Subject: METROWEST DCO EXAMINATION – ISSUE SPECIFIC HEARING 3 (ENVIRONMENTAL MATTERS) – ENVIRONMENT AGENCY WRITTEN RESPONSE TO AGENDA ITEM 5 (FLOOD RISK, DRAINAGE AND CONTAMINATED WATERS)

Our ref: WX/2019/133441/01-L09
Your ref: TRO40011
Date: 10 January 2021

**METROWEST DCO EXAMINATION – ISSUE SPECIFIC HEARING 3
(ENVIRONMENTAL MATTERS) – ENVIRONMENT AGENCY WRITTEN RESPONSE
TO AGENDA ITEM 5 (FLOOD RISK, DRAINAGE AND CONTAMINATED WATERS)**

Figure N-23: Pre Development, 20year return period event in 2115 ,Tidal

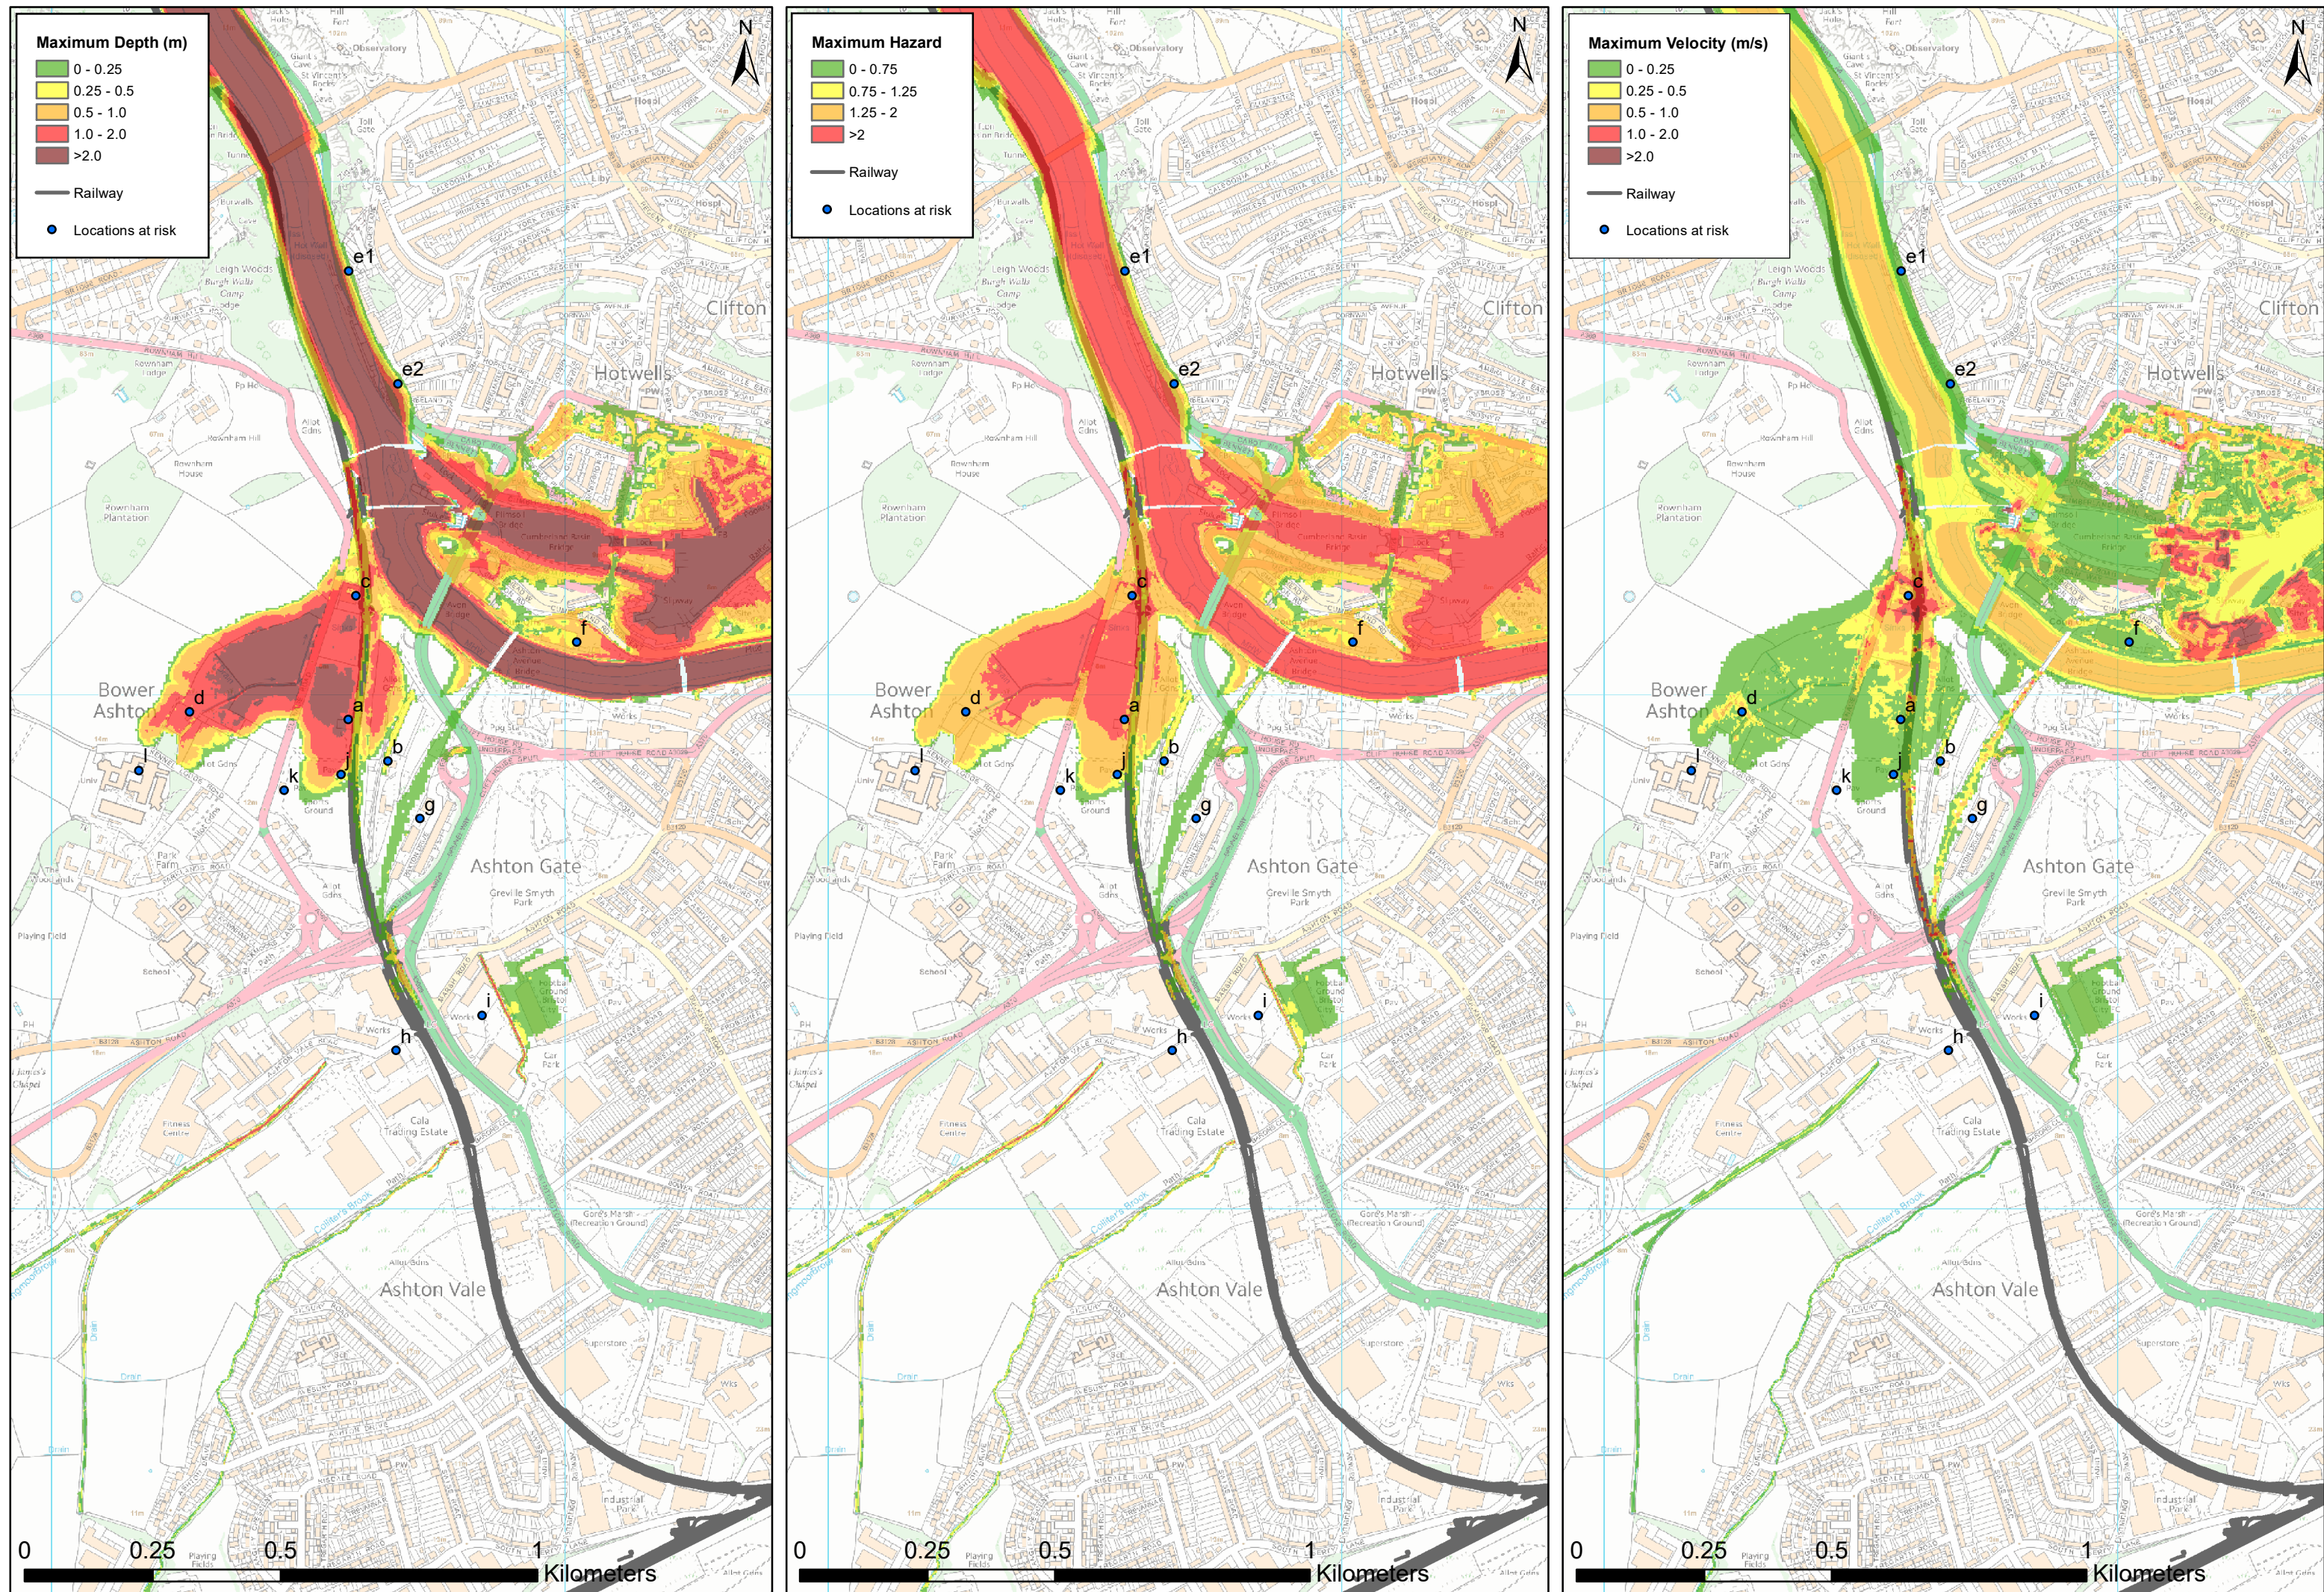
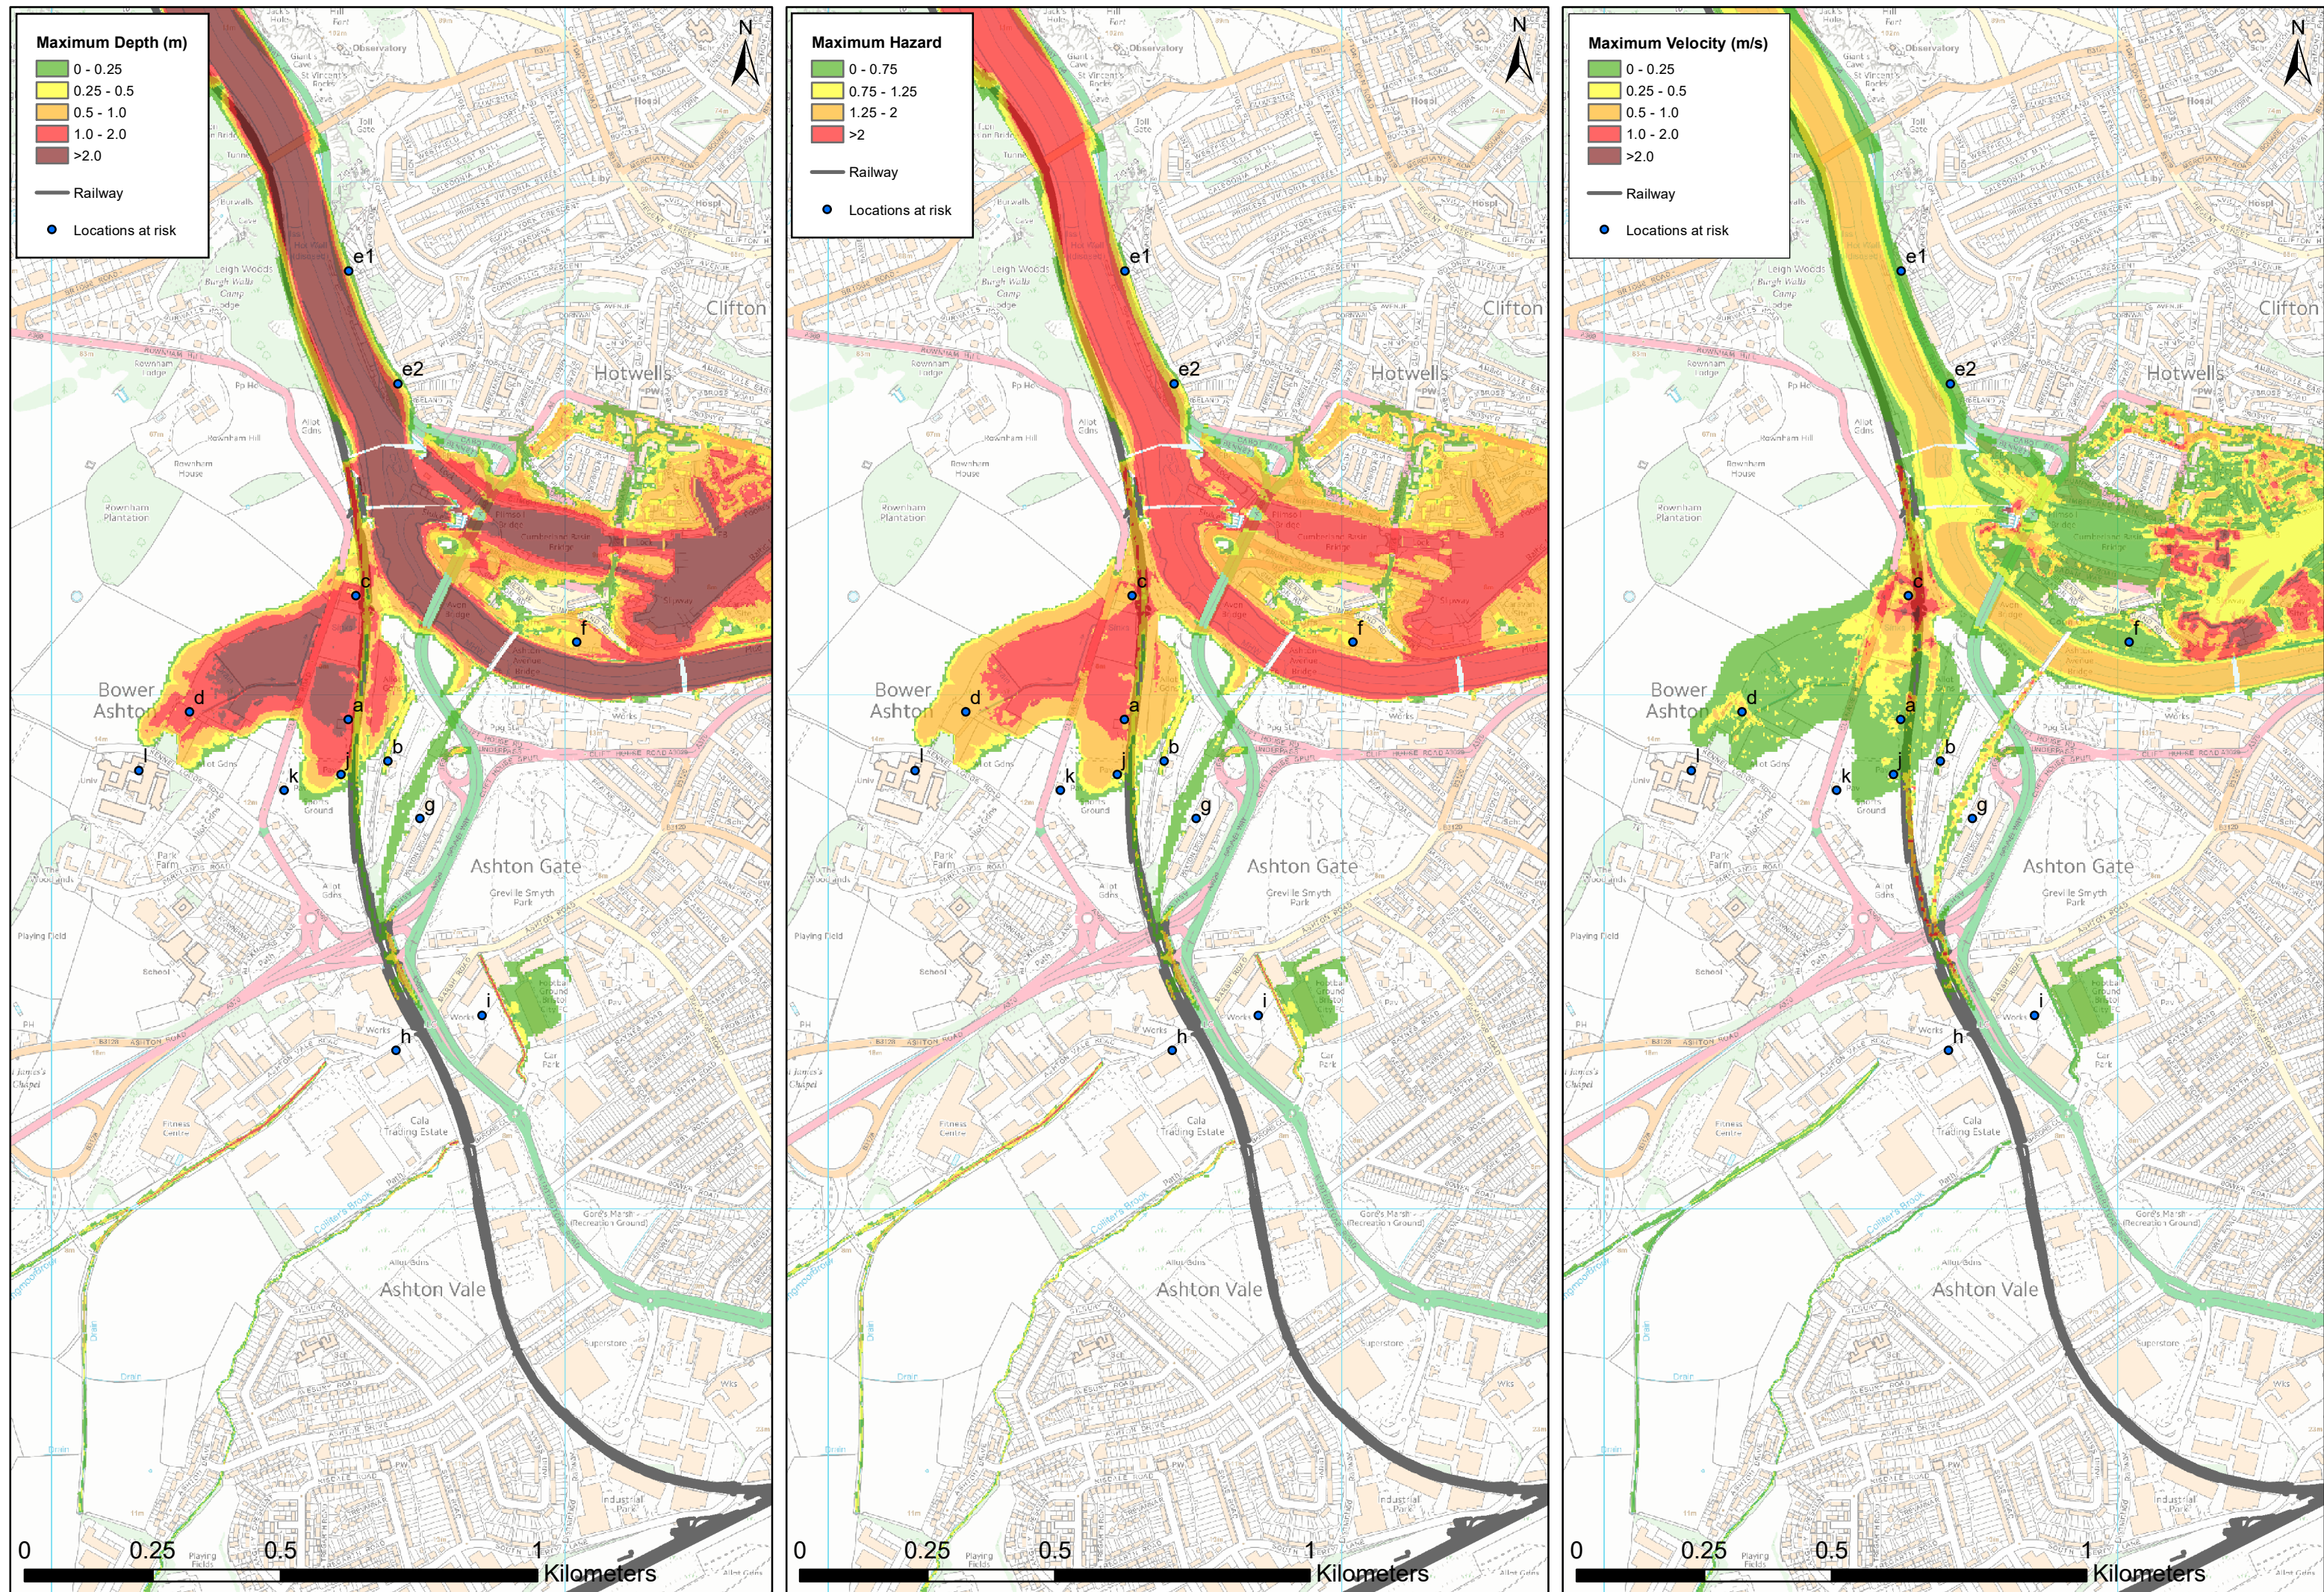
The Flood Risk Assessment (FRA) submitted in support of the proposal, has demonstrated that part of the site is in functional floodplain (Flood Zone 3b) and will, as a consequence, flood at a return period as low as 1 in 5 years at present. With the predicted impact of climate change, the frequency of flooding (and flood depth) increases to a potential 5 times a year in 2115.
